**WELWYN HATFIELD BOROUGH COUNCIL
EXECUTIVE DIRECTOR - PLANNING, PUBLIC PROTECTION AND GOVERNANCE**

Application No: 6/2017/1476/HOUSE
Location: 31 Selwyn Crescent Hatfield AL10 9NL
Proposal: Erection of first floor front, side and rear extensions
Officer: Mrs K Charles

Recommendation: Refused

Block Scale Plan 1:150

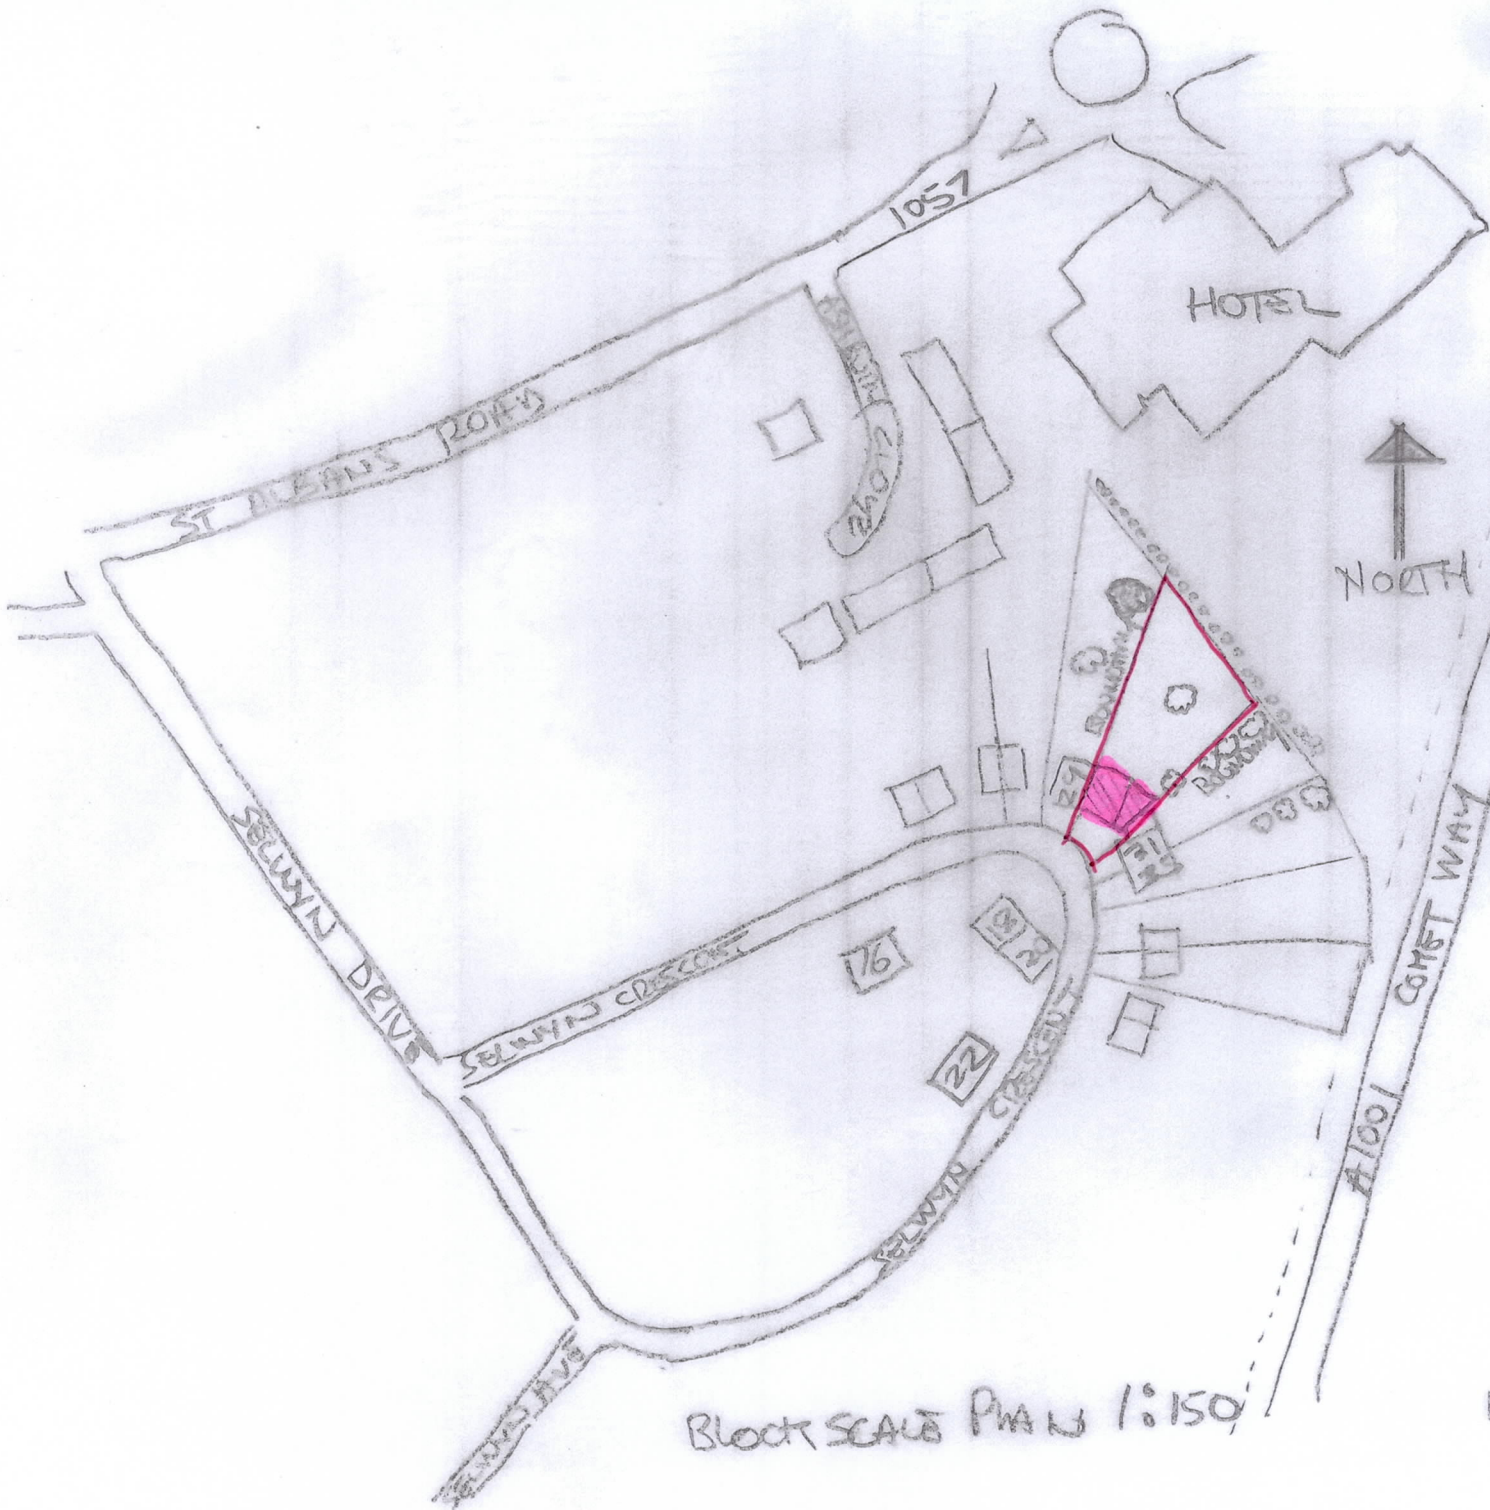
There are a number of trees along the boundary of No.31 and 33 Selwyn Crescent which could be harmed if development were to be approved. Although the trees do not have a high amenity value, one or more of the trees do not stand within the application site. There is no indication that the application has considered these trees through an Arboricultural Implication Report. It is also possible that a neighbouring tree will immediately physically encroach onto the proposed extension, this conflict does not appear to be considered.

Should the application be approved a condition should be placed on the approval for the applicant to submit a Tree Protection Statement for the tree(s) either on, adjacent or on the roadside. It should cover how the applicant will ensure the tree parts, both above or below ground, will not be directly or indirectly damaged. The scale of the document should reflect the importance of the trees in the landscape and the size of the building works. The statement should reflect BS5837:2012 (Trees in relation to design, demolition and construction - Recommendations). For example, to avoid root damage by soil compaction, all site vehicles shall not park or drive on the verges. This Statement shall be submitted to the Council for approval before any works, including demolition, start on site

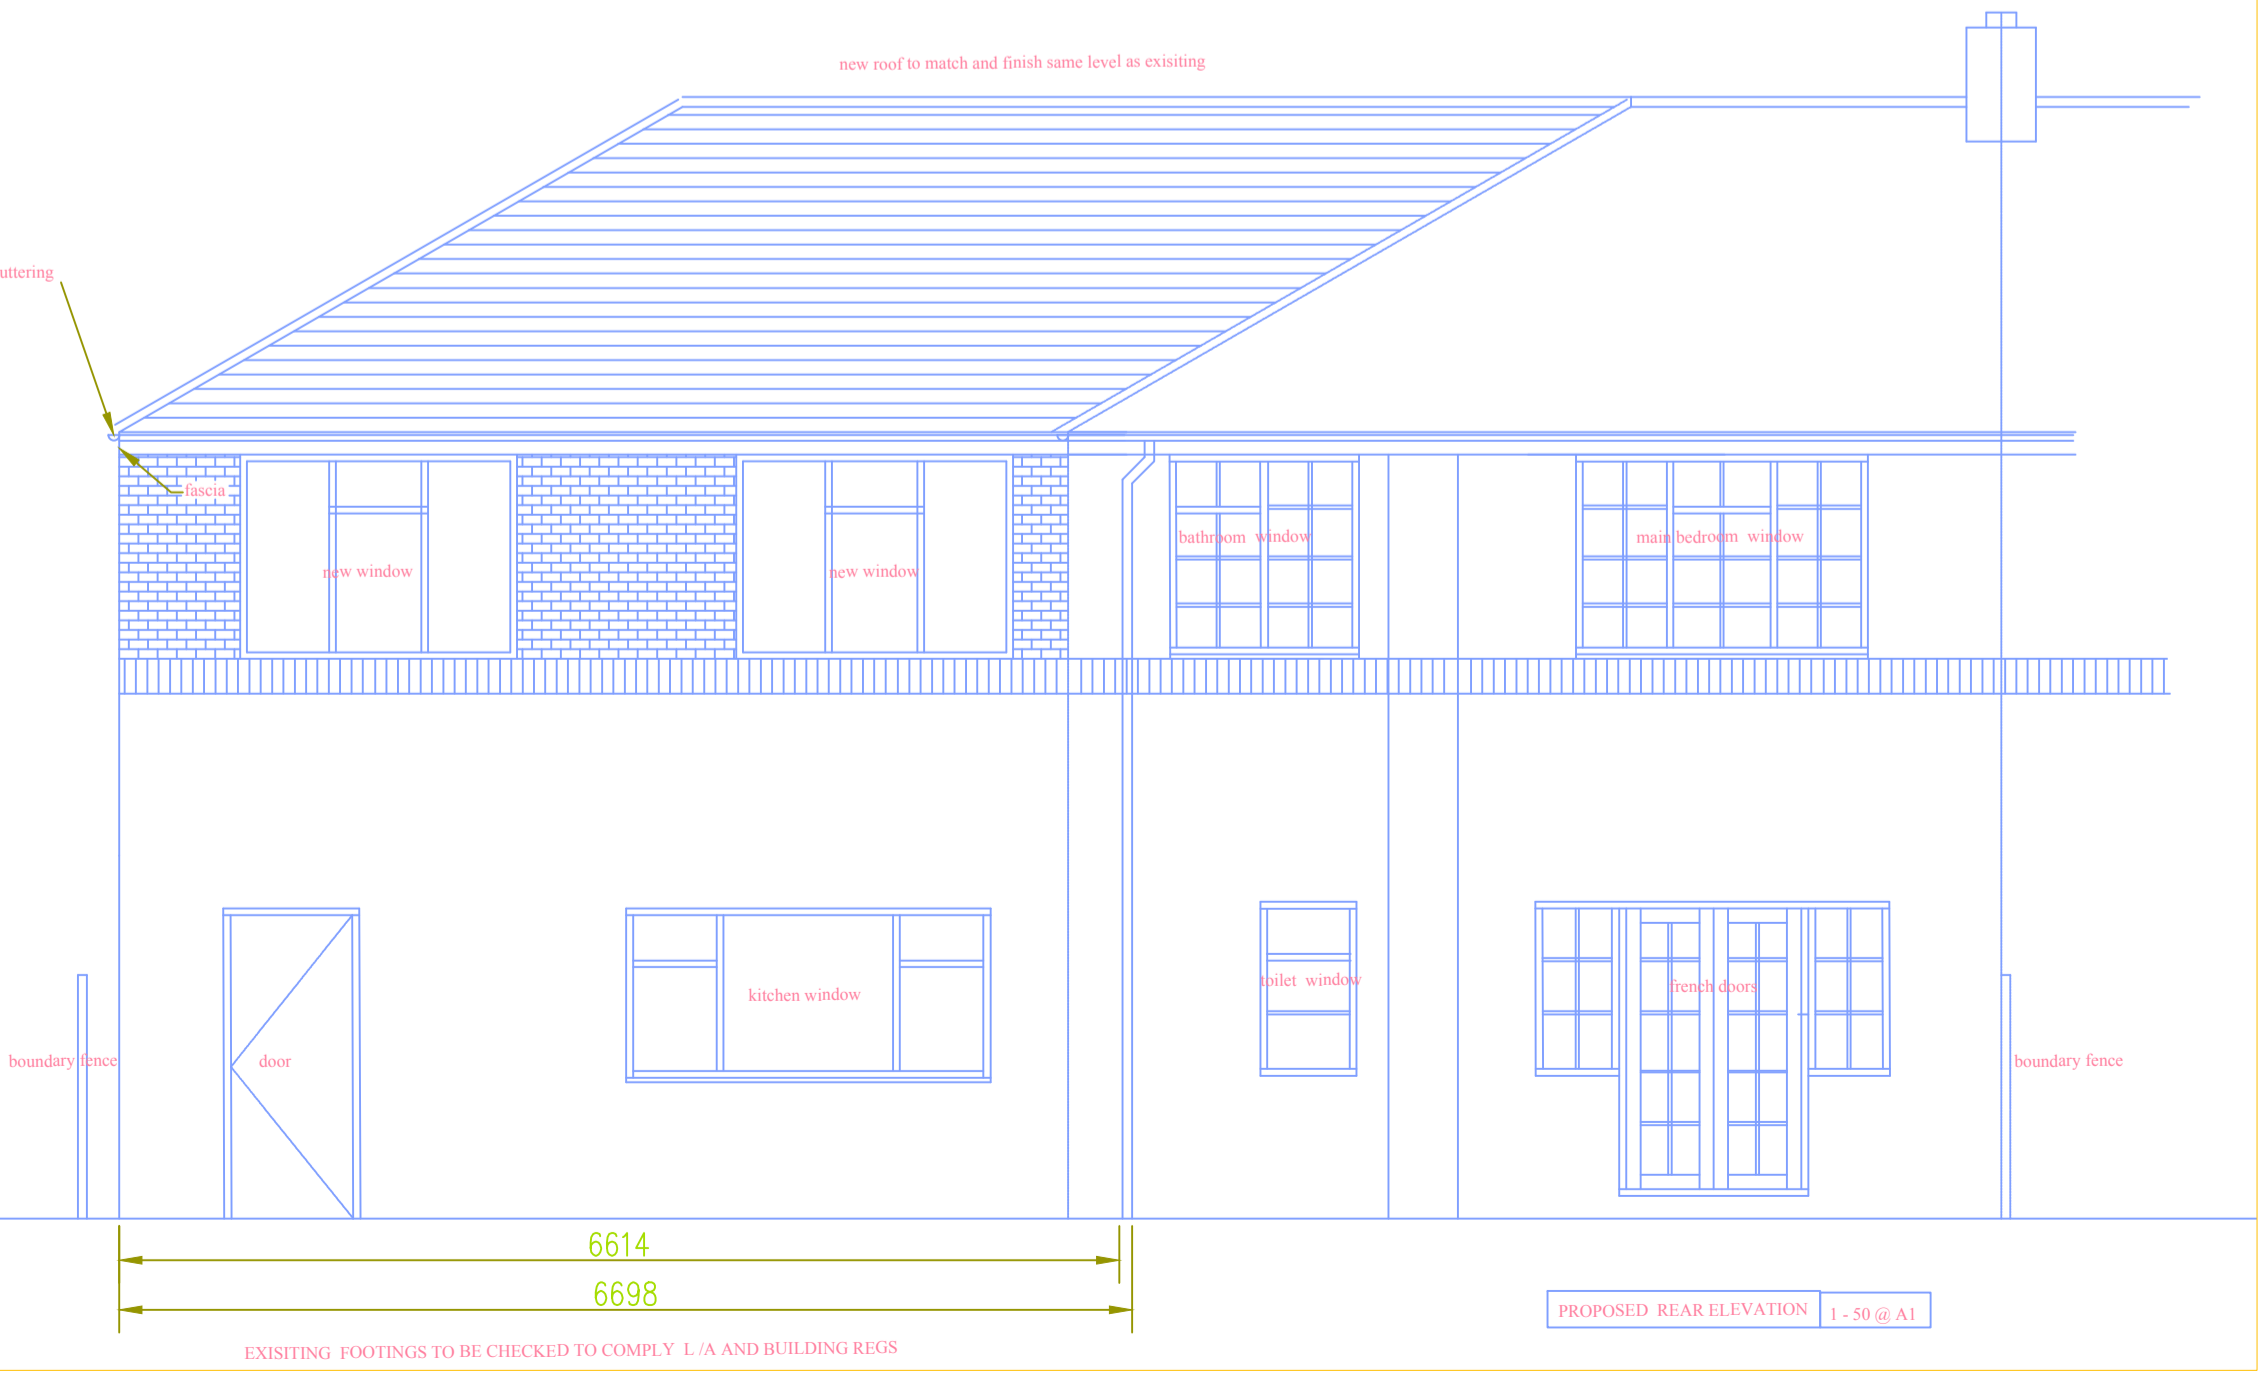
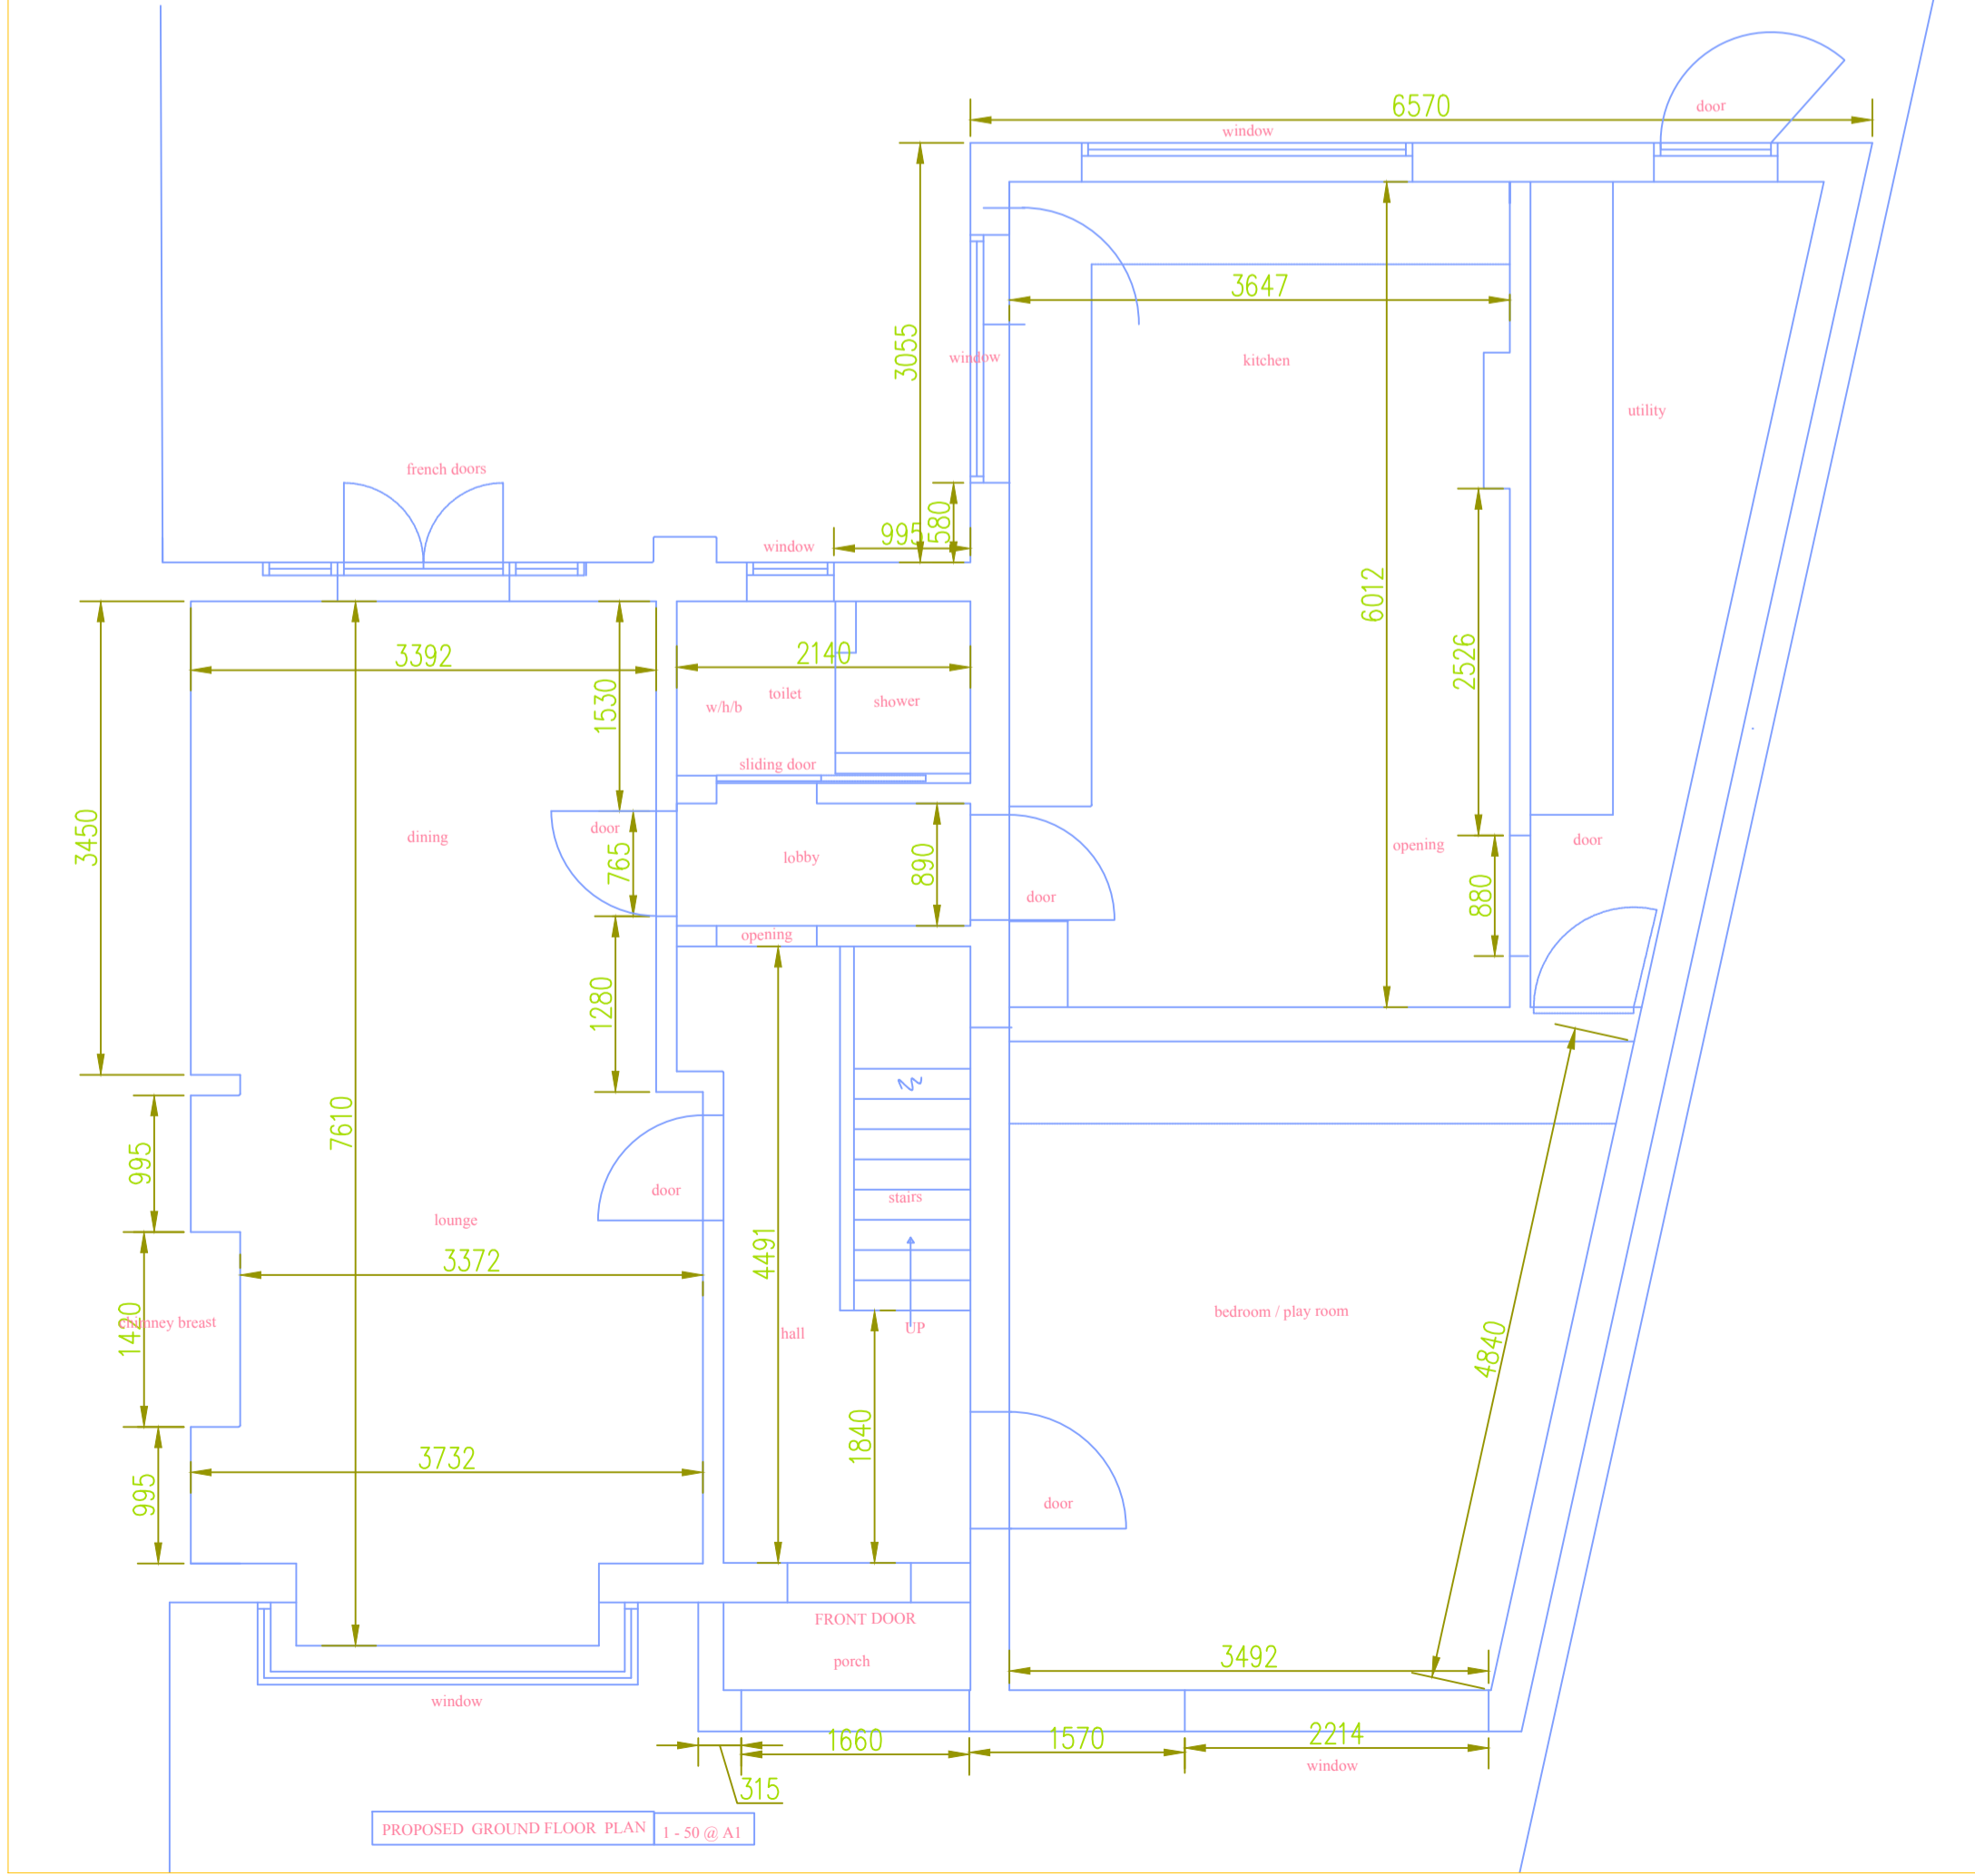
In terms of privacy, new first floor side windows serving a bedroom and family room would be installed. This window would present views toward the flank window of this adjacent property. As such, in the event of a grant of planning permission, it would be considered necessary and reasonable for this window to be glazed in obscure glass and have a restricted level of opening in order to maintain the levels of privacy enjoyed by the occupier(s) of No. 33 Parsonage Lane. This property is attached to the host dwelling. It is not considered that the proposed development being single storey would result in a detrimental impact on the residential amenity of this neighbouring occupier in terms of loss of light, appearing unduly dominant or result in an impact on privacy.

The proposed development, by virtue of its scale and proximity to the flank boundary, would result in overdevelopment across the plot width of site, fail to reflect the established spacing of dwellings adjacent to and in the immediate locality of the site and represent an incongruous addition relative to the character and design of dwellings in the street scene. Accordingly, this proposal represents a

1. The proposed development, by virtue of its scale and proximity to the flank boundary, would result in overdevelopment across the plot width of site, fail to reflect the established spacing of dwellings adjacent to and in the immediate locality of the site and represent an incongruous addition relative to the character and design of dwellings in the street scene. Accordingly, this proposal represents a poor standard of design contrary to Policy D1, D2 and GBSP2 of the Welwyn Hatfield District Plan 2005, Supplementary Design Guidance (Statement of Council Policy 2005) and relevant parts of the National Planning Policy Framework 2012
